From: Amanda Scholes on behalf of Planning.Responses
Sent: 18 August 2017 10:14
To: Planning Scanning
Subject: FW: AL/11/17/DOC - Land East of Hook Lane - Discharge of Conditions - Drainage information

From: Paul Cann
Sent: 16 August 2017 14:57
To: 'Steve Worthington'
Cc: Barber, Robert; Michael Eastham; Terry Seymour; 'Kennett, Darren'; Karren Johnston; Michael Eastham
Subject: RE: Land East of Hook Lane - Discharge of Conditions - Drainage information
Importance: High

Subject: RE: Land East of Hook Lane - Discharge of Conditions - Drainage information

Drawing No. **BSO/E4462/454 C3**

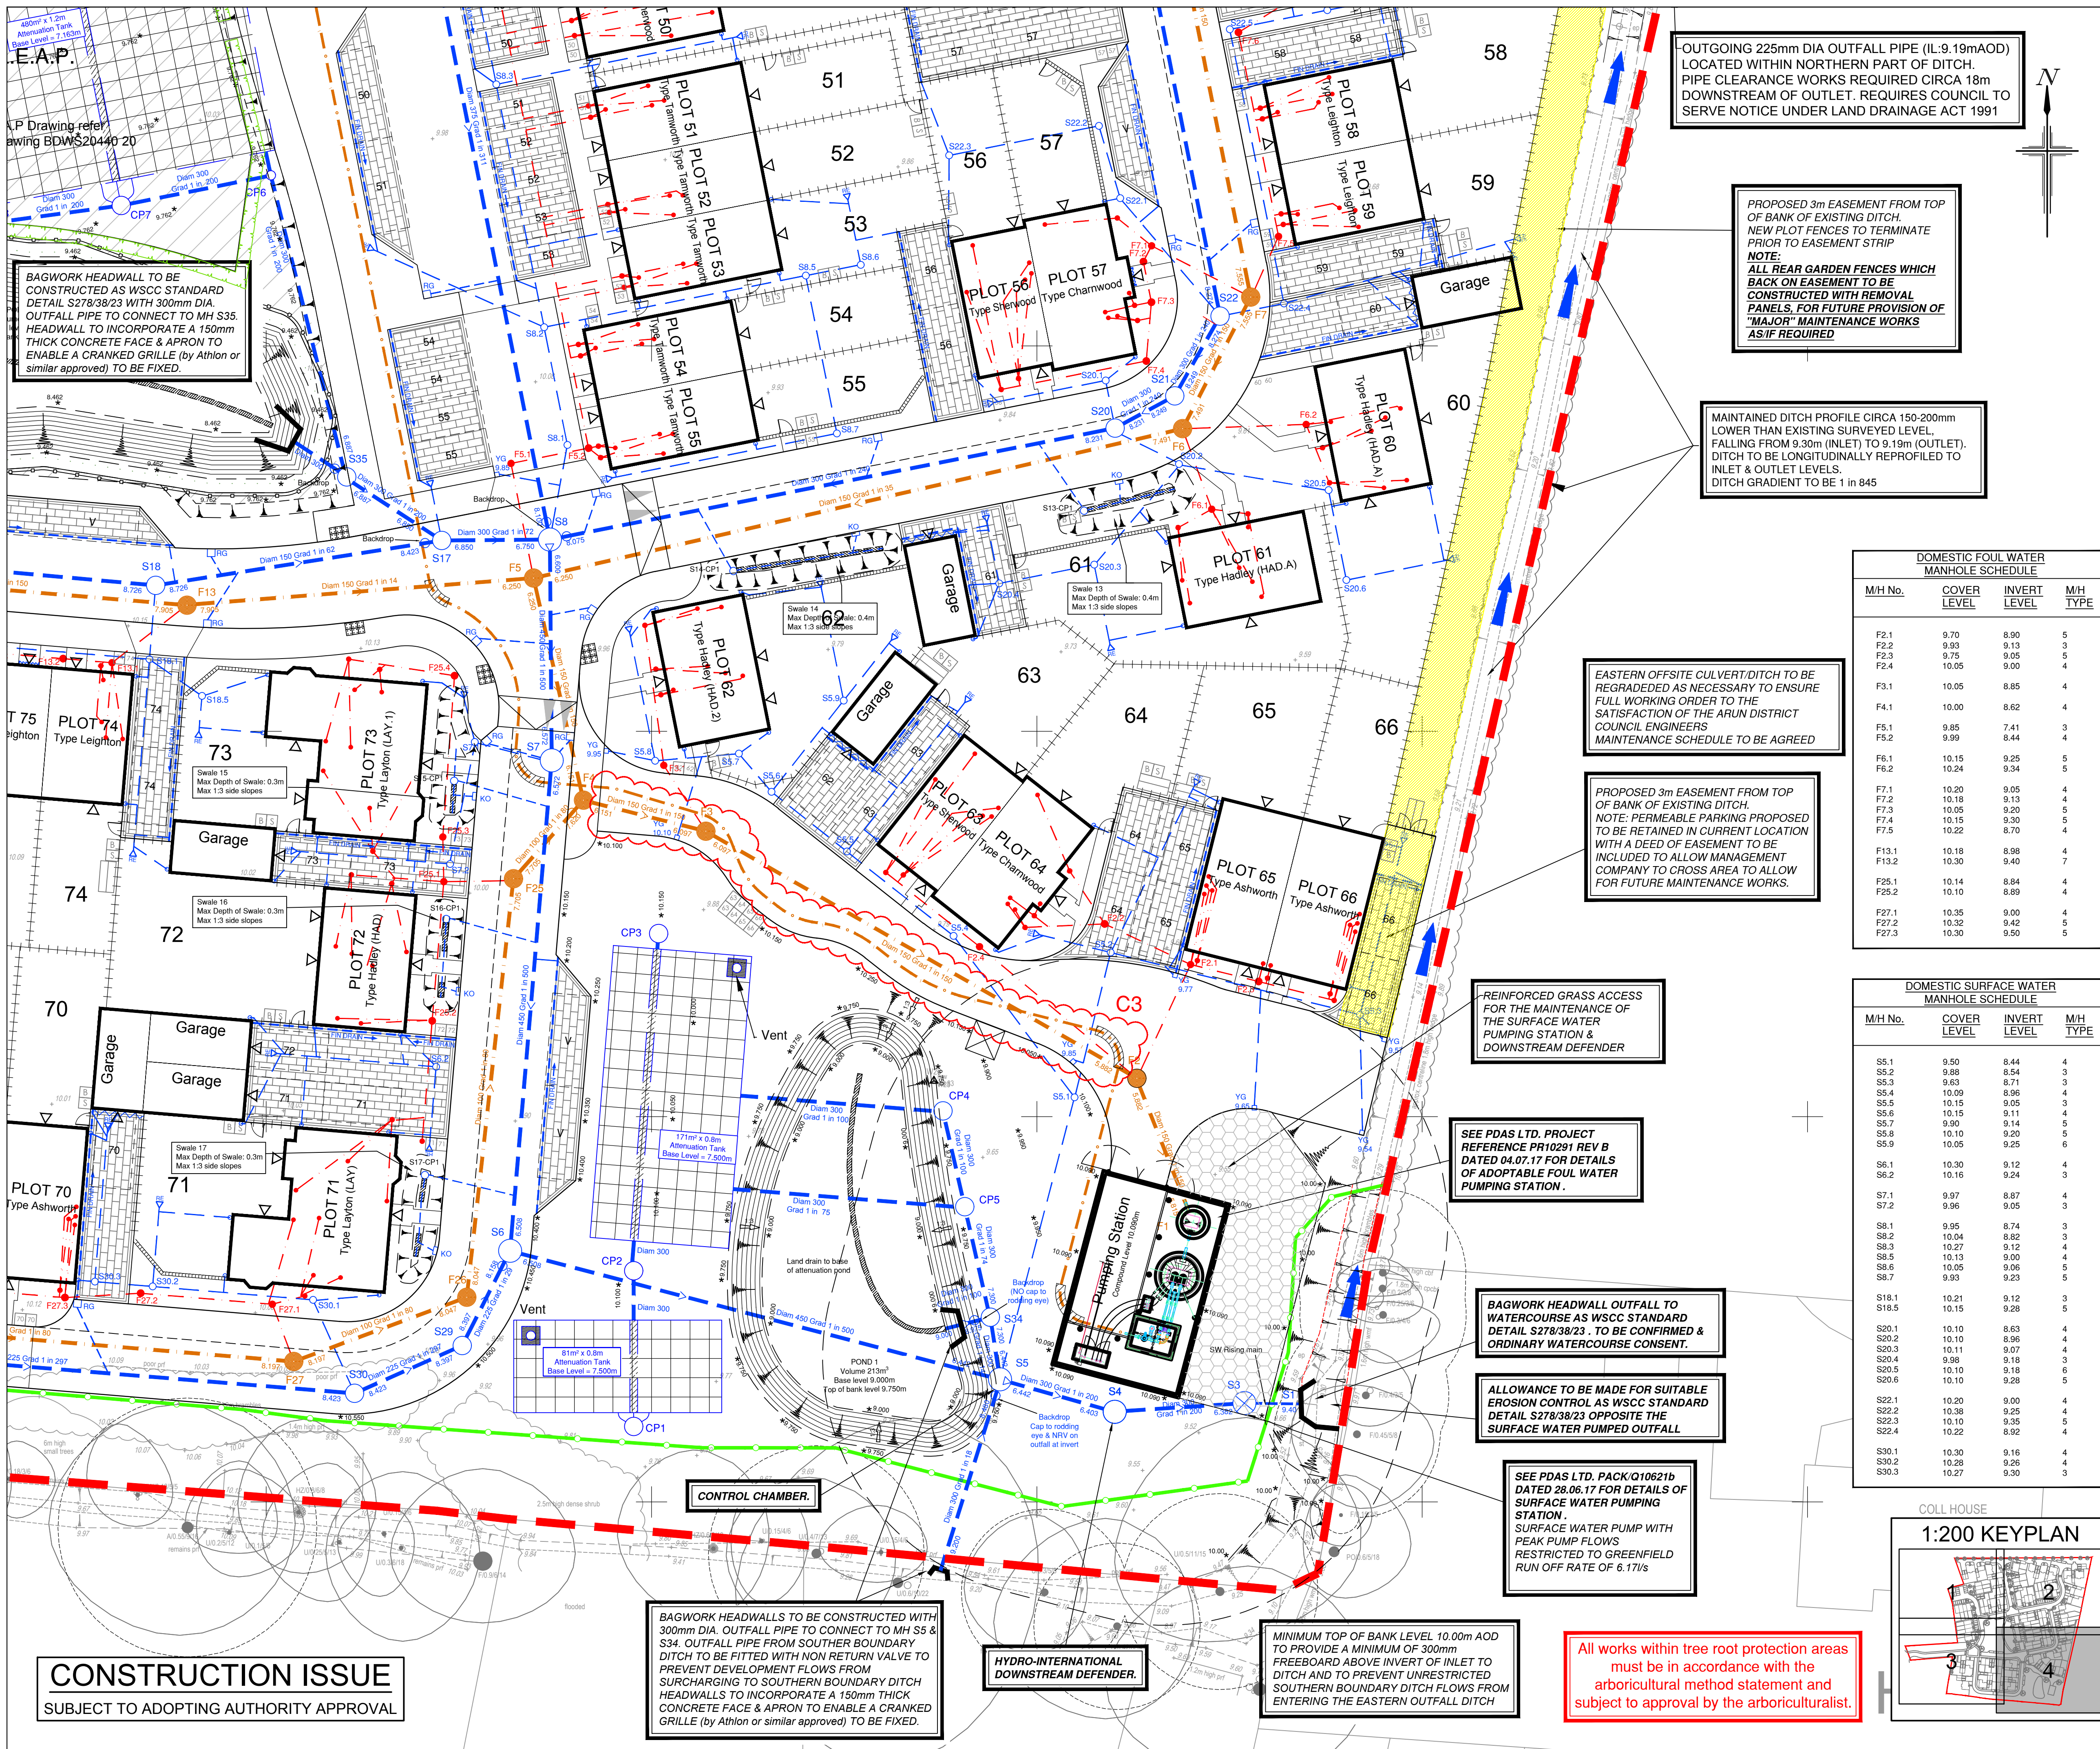
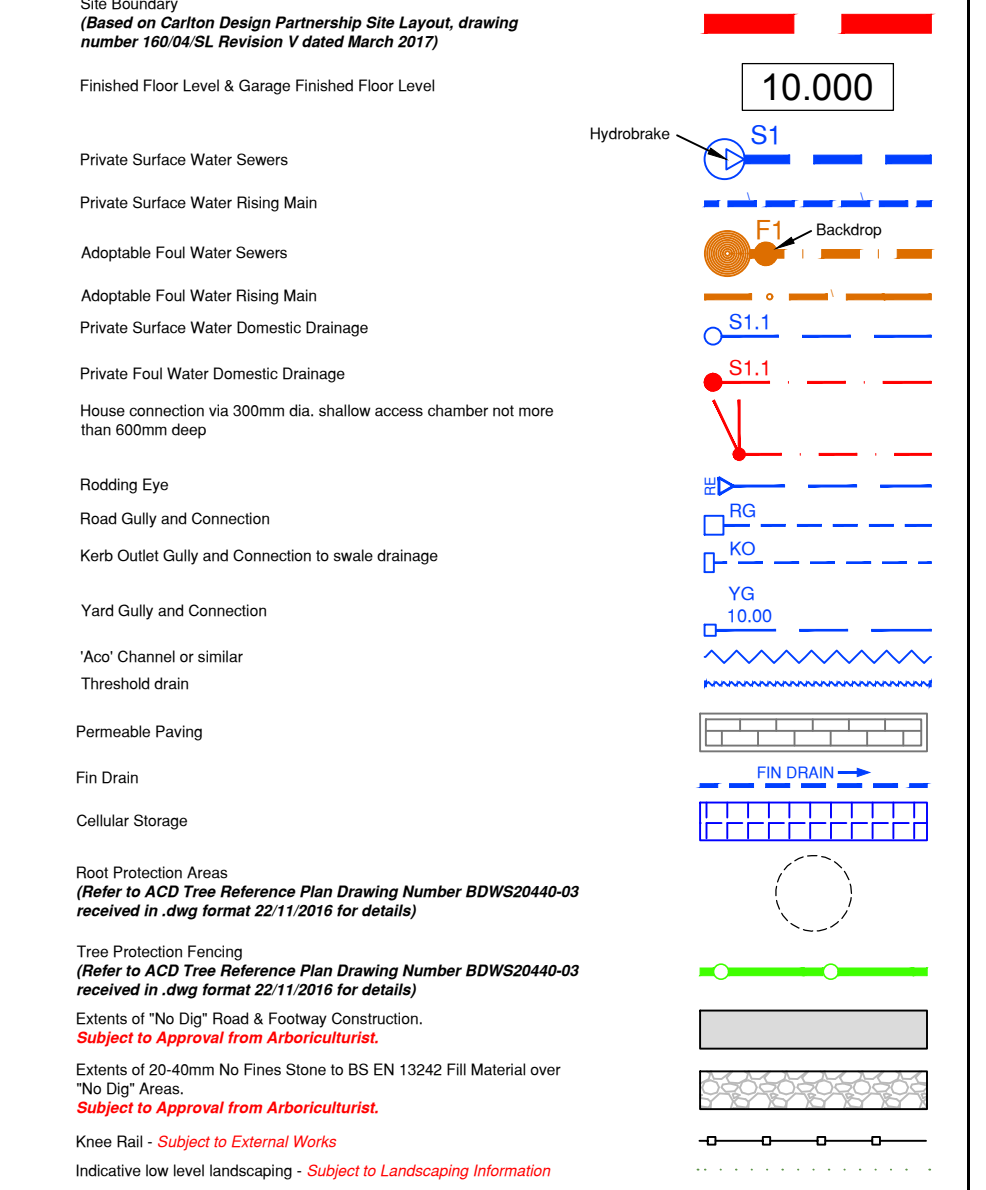
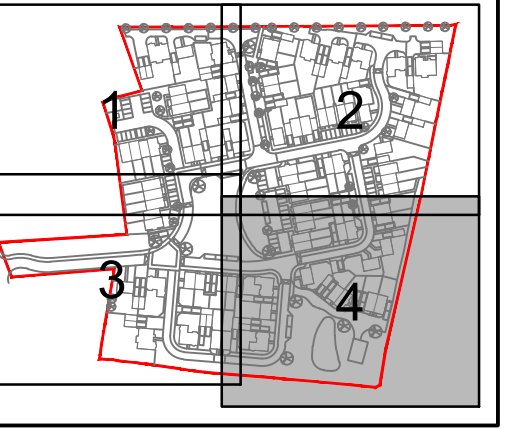
1. Noted.
2.
 - a) Noted
 - b) Noted but 1.007 still has a different gradient to that shown on the plan.
 - c) Noted
 - d) Noted
 - e) 6.000 and 6.001 have different gradients to that shown on the plan.
 - f) Noted
 - g) Noted
 - h) Flooding is predicted on pipes 1.000, 1.001, 3000, 3.001, 2.002, 5.000, 5.001, and 1.003. Please advise of flood extents/depths. I assume available storage in the permeable paving/swales hasn't been allowed for in the calculations?
3. Could you point out in document where hydrobrake maintenance is covered and where it specifies the chosen pumping station alarm arrangement/notification.
4. Detail to protect the northern boundary noted, but I can't see how the eastern boundary will be dealt with in order to cater for surface runoff/ seepage through the bank, from the higher ground. I.e. perhaps an impervious clay barrier/French drain arrangement?

4. I don't think a fin drain is the answer as this could potentially move flows quicker to the lower areas and may not totally eradicate the chance of water passing to the lower ground in Cherry Trees during extreme conditions. An impermeable barrier built into the construction where adjacent to the northern and eastern boundaries of Cherry Trees should be considered. A detail will be required.

Your point 4 is addressed on Drawing 453 C3
